From: Anita Gardner
Sent: 12 April 2018 11:54
To: Karen Parsons
Subject: FW: A/8/18/PL - Land to rear of The Cottrells
Attachments: MP 01 02revC.PDF; ADC 962 15.pdf; ADC 962 14 A.PDF; ADC 962 13 A.PDF

From: Anita Gardner [<mailto:Anita.Gardner@arun.gov.uk>]
Sent: Thursday, February 22, 2018 4:24 PM
To: [REDACTED]
Subject: A/8/18/PL - Land to rear of The Cottrells

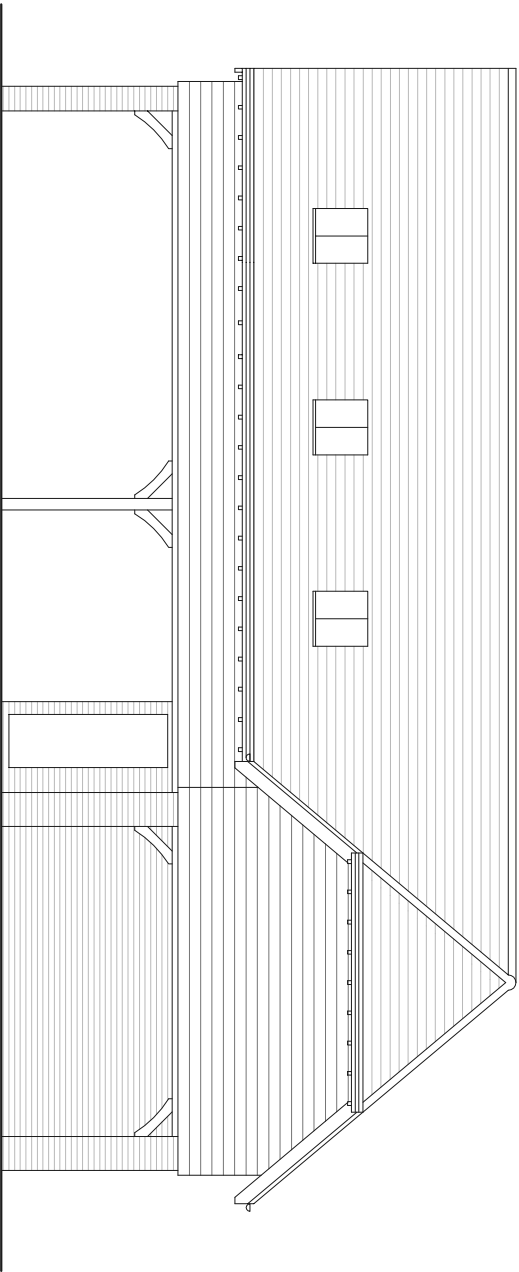
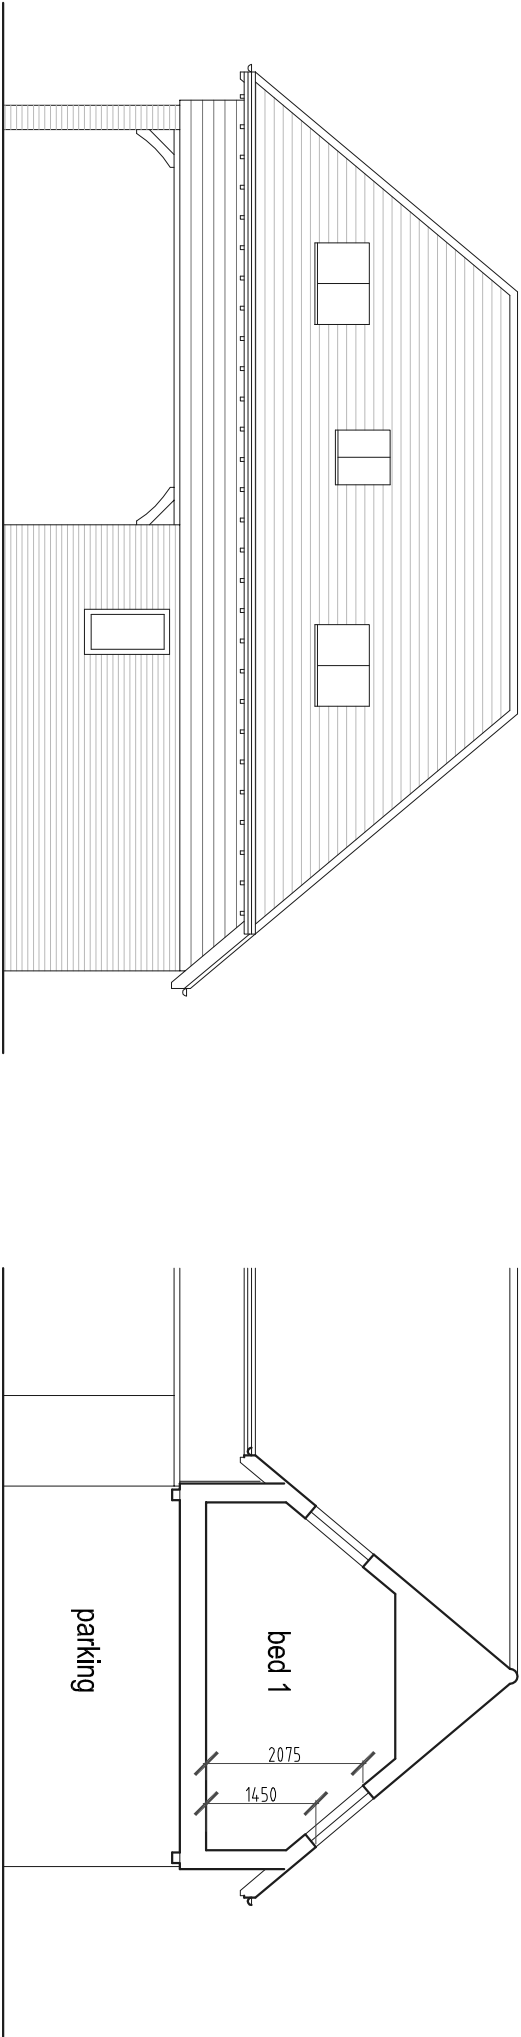
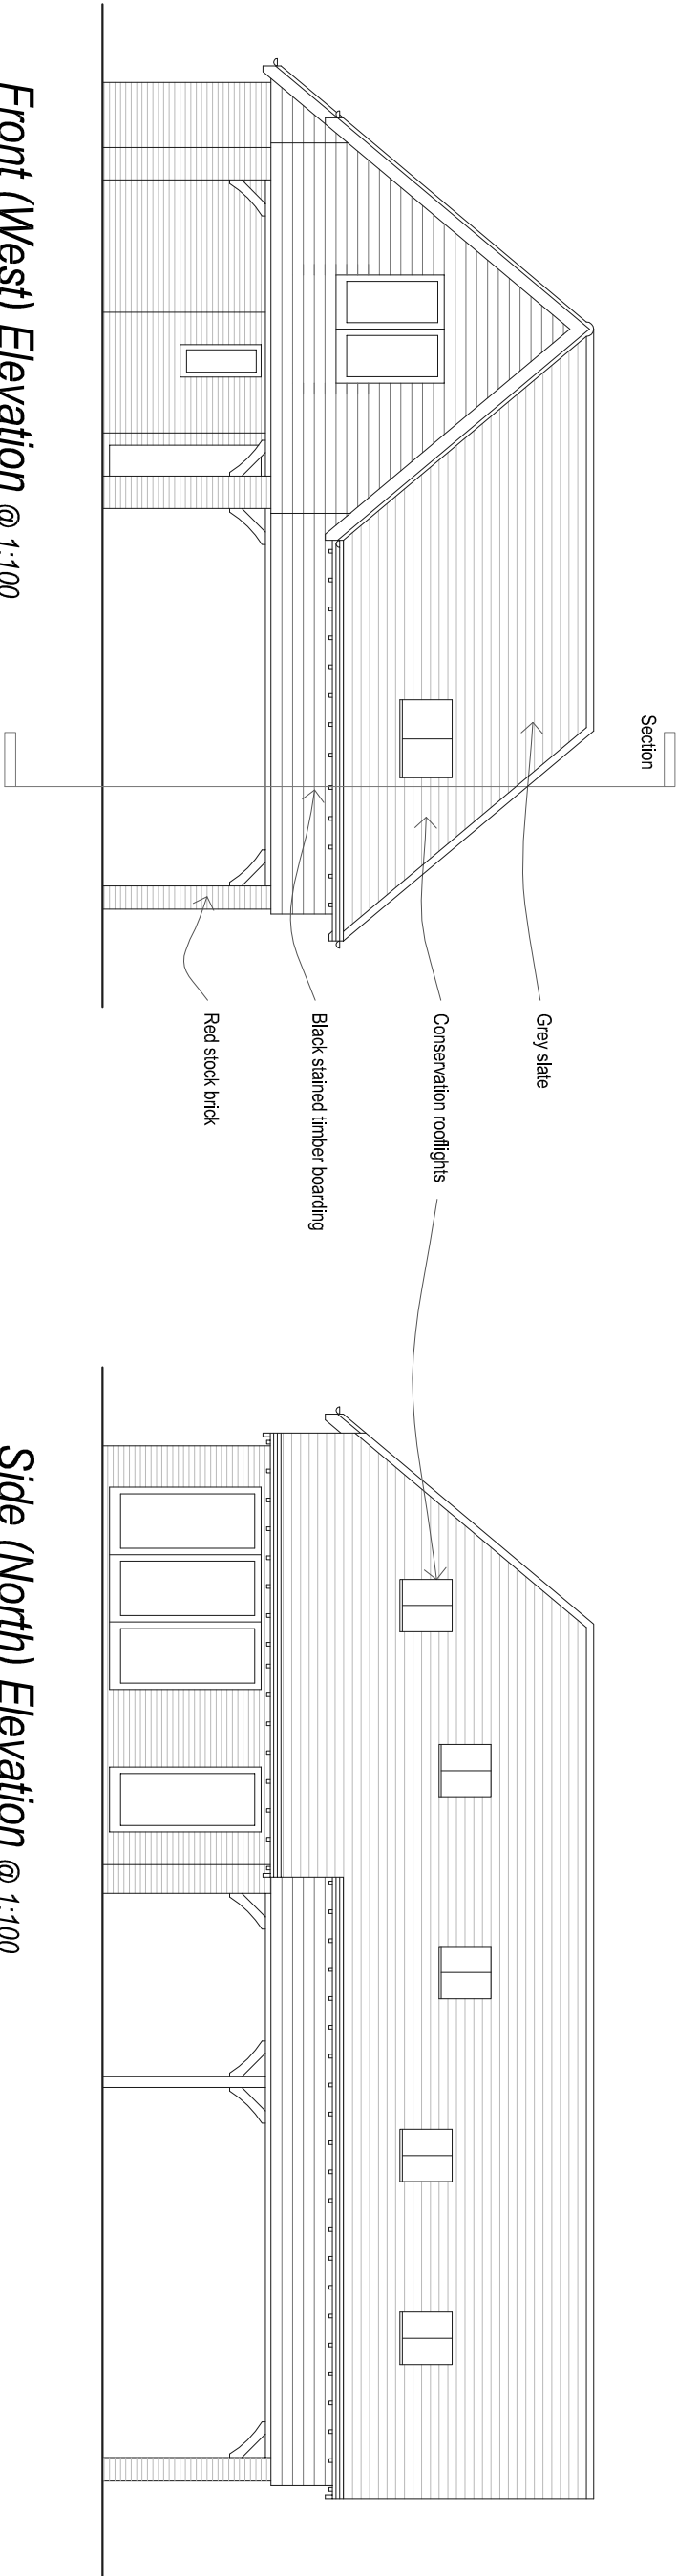
Further, I note that the proposed south elevation plan does not correlate with the west elevation and should be amended to delete the gabled roof since the proposal relates to additional rooflights only. I will also require confirmation as to where the cross section is taken from and whether any of the rooflights are intended to be a means of escape. It would be my intention to consider any that are not indicated as such to be conditioned to be non-opening and possibly obscure glazed depending on their position. It would also be helpful to have a cross section of the roof lights on the other 2 elevations (north/south) and its position indicated on a floor plan. My preference would also be for the elevations to be provided at 1:50 scale for clarity.

I attach amended and new drawings No ADC 962/13A, 14A & 15. I have corrected the south elevation and added a 1:50 scale section as requested. I have also re-measured the rooflight heights and confirm that none of the eills are lower than the previous approval heights 1500mm. I also attach the approved drawing MP 01 02 C showing the dimensioned section which confirms this.
